Thank you for the opportunity to comment on the short plat of approximately 6.32 acres into 2 lots, proposed by Anne Watanabe [SP 07-167]. We have reviewed the application and have the following comments.

RE: Duke Short Plat, SP-07-167

TO: Kari Braniff, Community Development Services
FROM: Christina Wollman, Planner II *CW*
DATE: April 17, 2008
SUBJECT: The Duke Short Plat SP-07-167

SP-07-XX

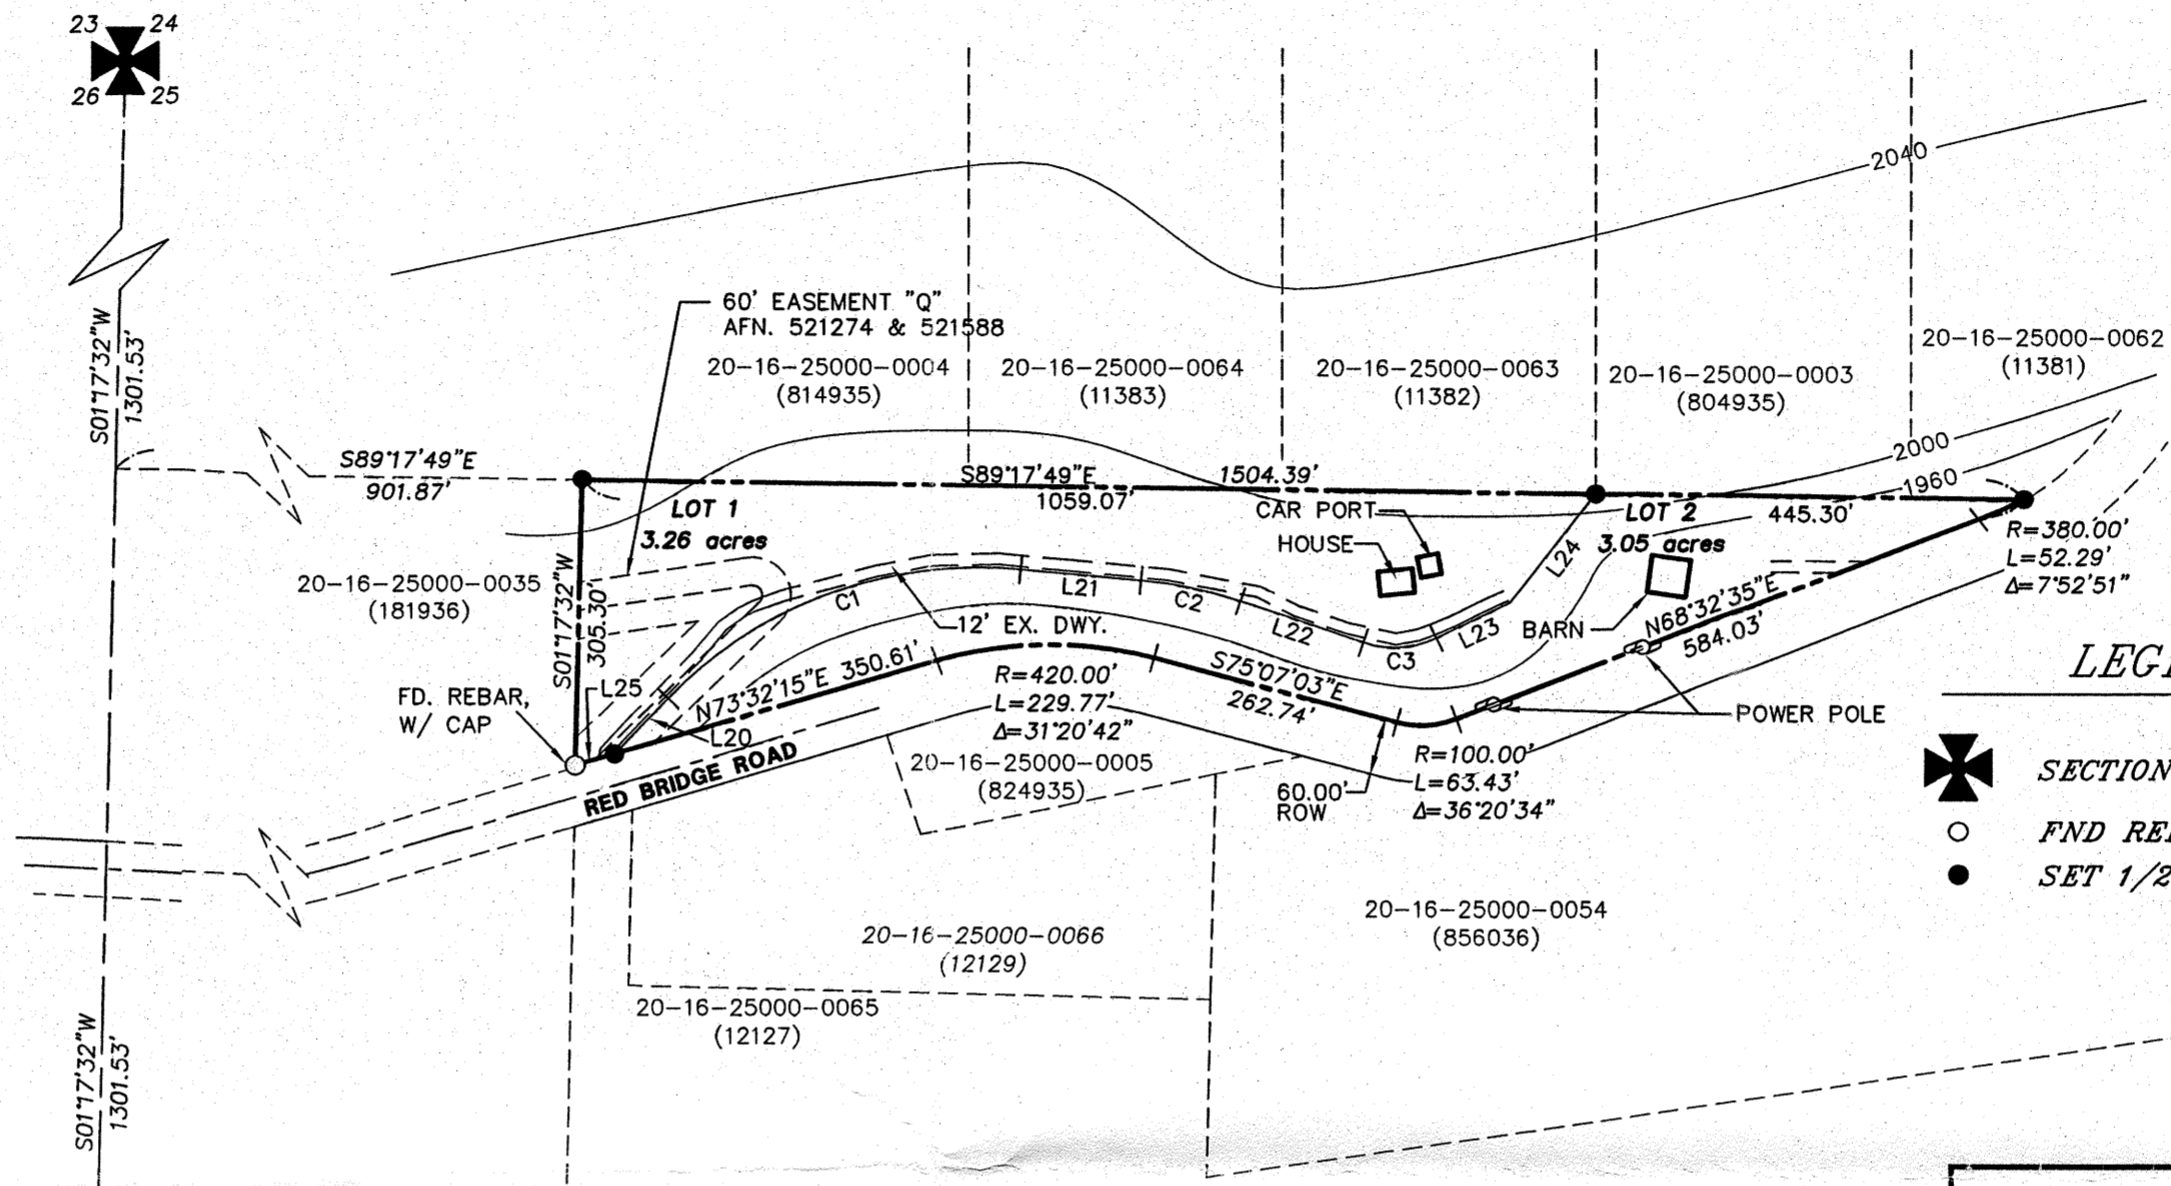
1. Tax Lot Number: The tax lot number listed in the Treasurer’s approval box appears to be incorrect.
2. Lot 2 Access: Access to Lot 2 is proposed to be directly from Red Bridge Road. If access is from the 60’ access easement additional improvements will be necessary, including the construction of a high density road that serves 3-14 lots, an emergency turnaround, and a road certification prior to receiving a building permit.
